Engineers Comments Regarding Surface Water Drainage & Land Drainage

Application No: AL/46/20/PL
Registered: 18th June 2020
Site Address: Wings Nursery Lidsey Road Woodgate PO20 3SU
Grid Reference: 493756 104078
Description of Works: Demolition of Wings House & the erection of 81 No. replacement dwellings (80 net new dwellings), access arrangements, sustainable drainage measures, public open space, landscaping & all other associated works. This application is a Departure from the Development Plan.

Drawing Status	INFORMATION		
Client	Southern Housing Group Ltd		
Project	Land at Wings Nursery Lidsey Road		
Drawing Title	Constraints Plan - Drainage and Flood Risk		
Scale	Date	Drawn By	Checked By
1:500	Jan. 2020	SPB	MJA
Drawing No.	Rev.		
D1757-PL101	-

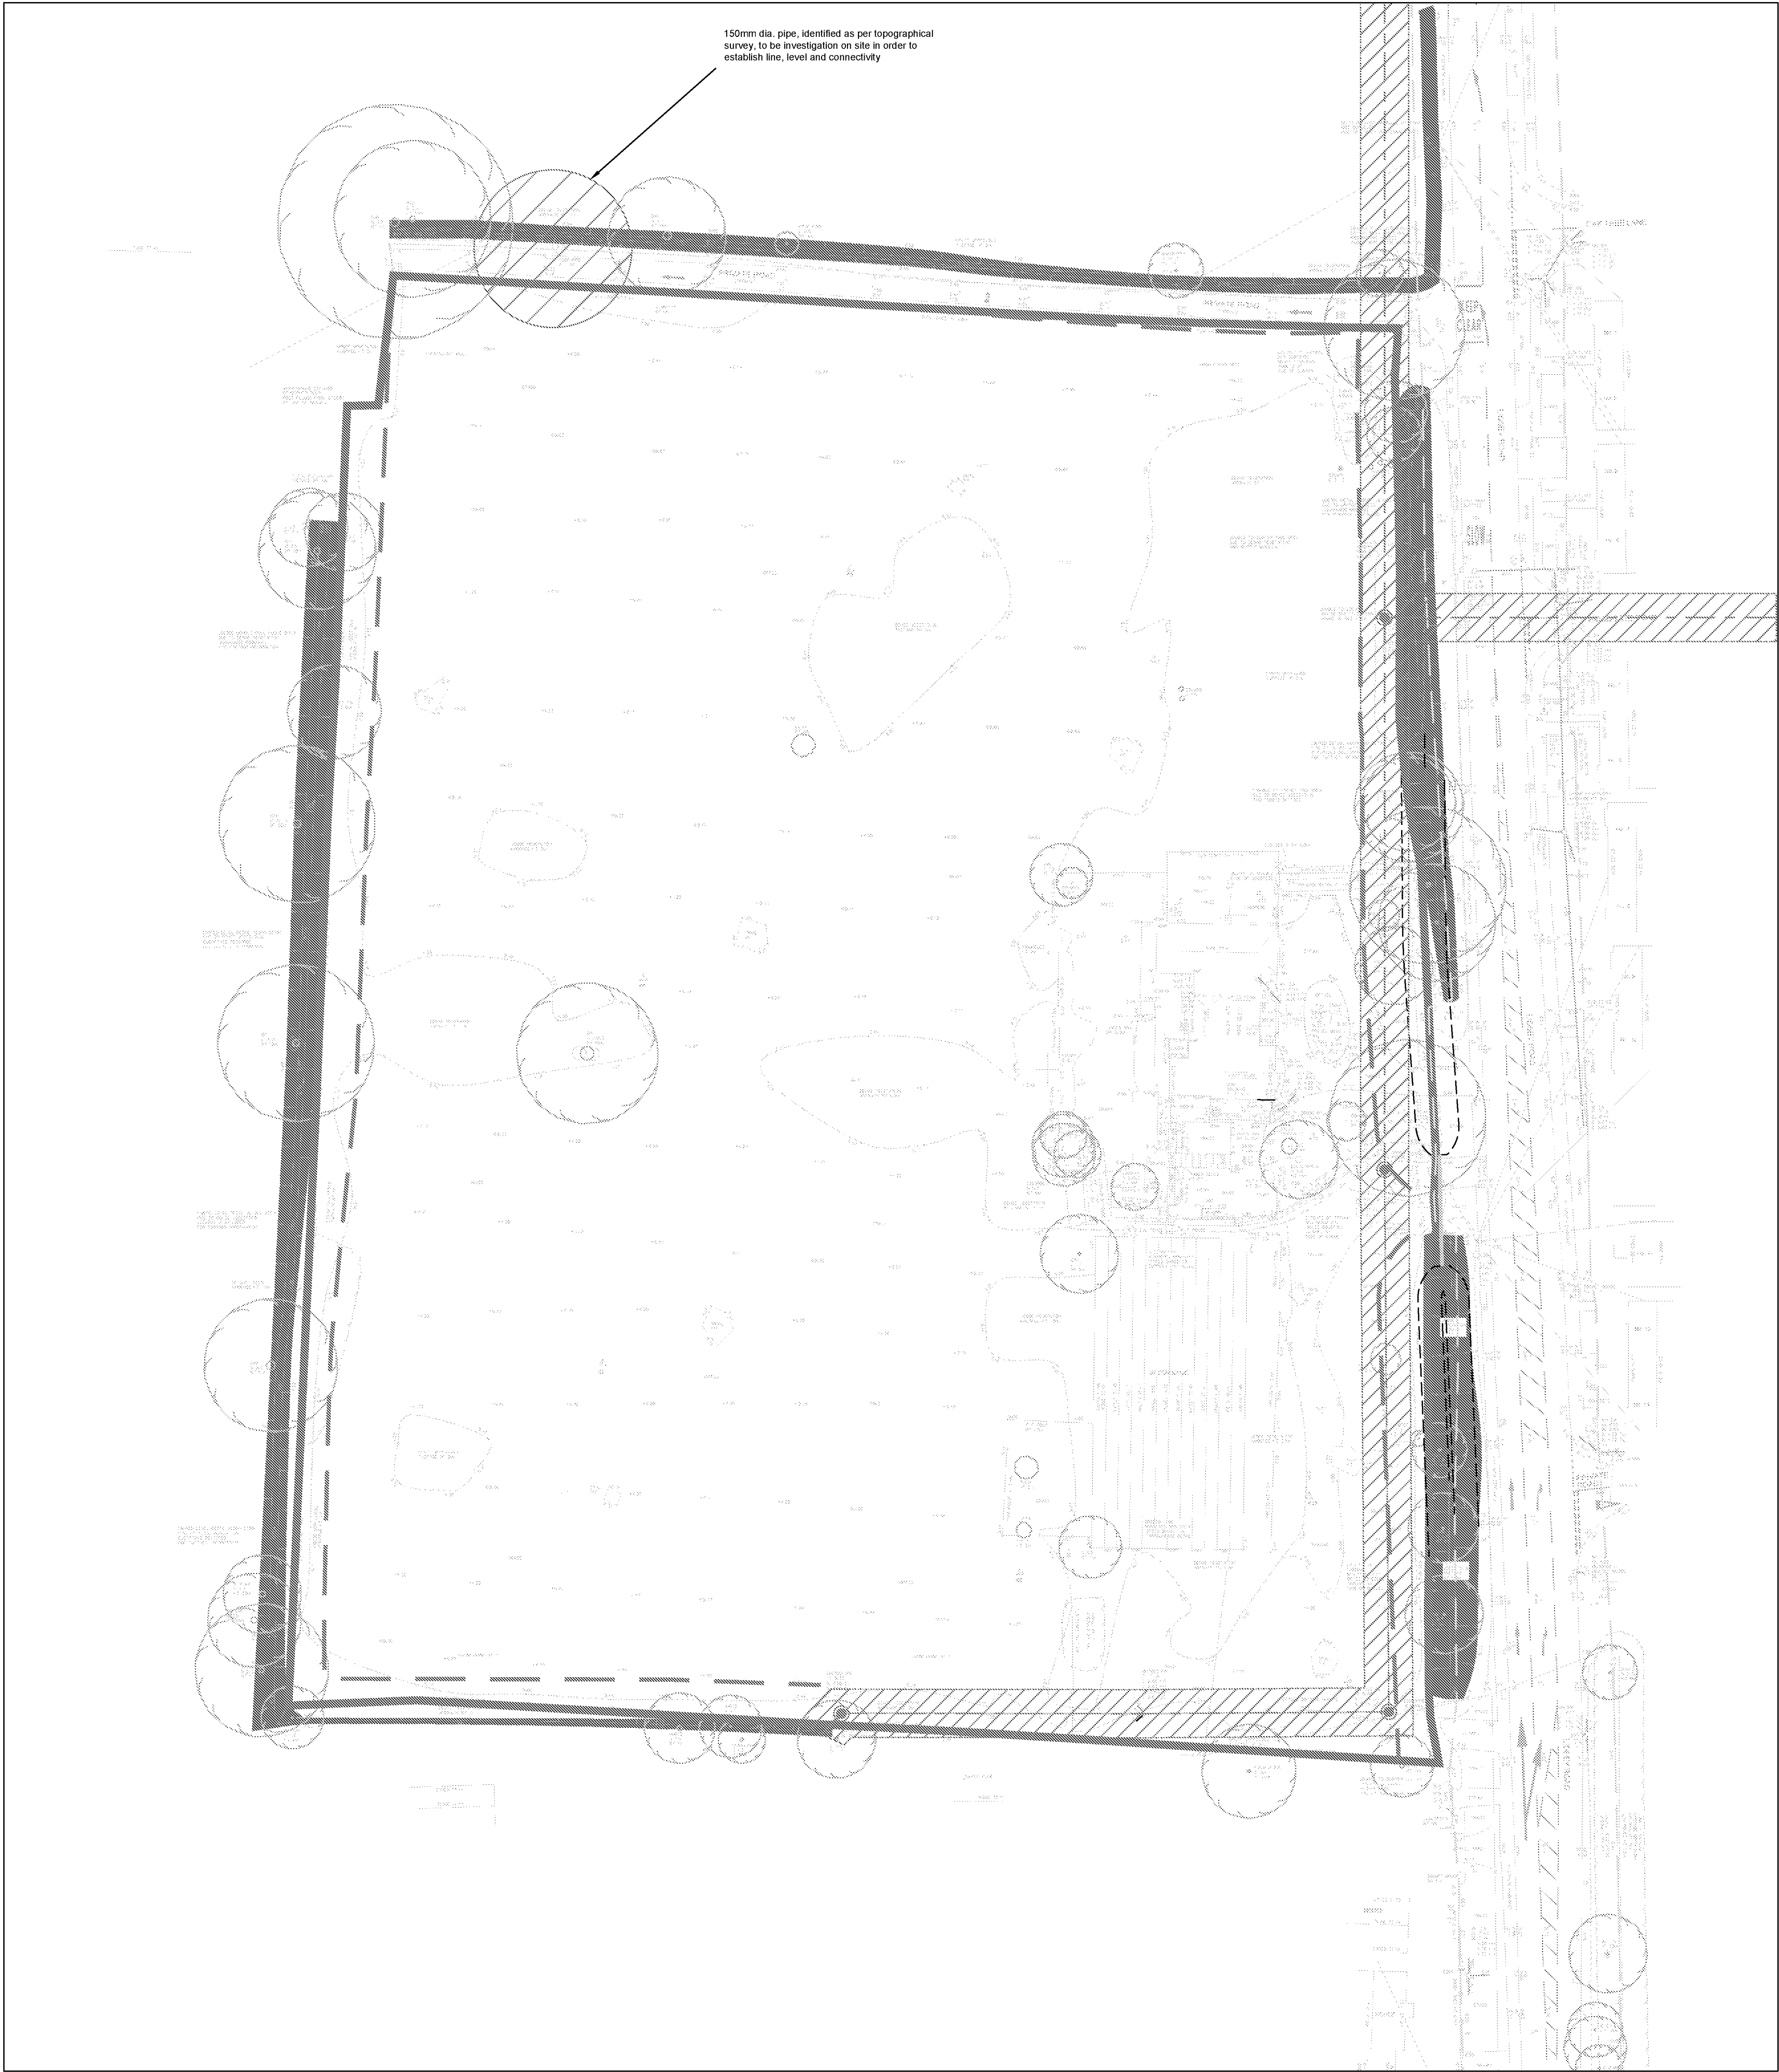
The existing watercourses on the western and eastern boundaries are noted. According to the topographical survey the western ditch possibly flows both north and south. Further investigations are required to determine more of the extent of this system to ensure no part crosses the site. This investigation should include trial trenches where there is a noticeable low area running west to east, to ensure there is no culvert in existence. The outcome of these investigations may affect the proposed development layout.

All boundary fences/structures must be kept at least 3 metres from the top of the bank of the western boundary ditch in order to provide a buffer for maintenance, etc. It appears that the development layout is not achieving this requirement and will therefore require amendment.

The intention to improve the eastern boundary ditch and culverts is noted and will be welcomed and will be agreed via the appropriate planning condition and Land Drainage Consent. The western boundary ditch can be discussed further once more is known about its extent.
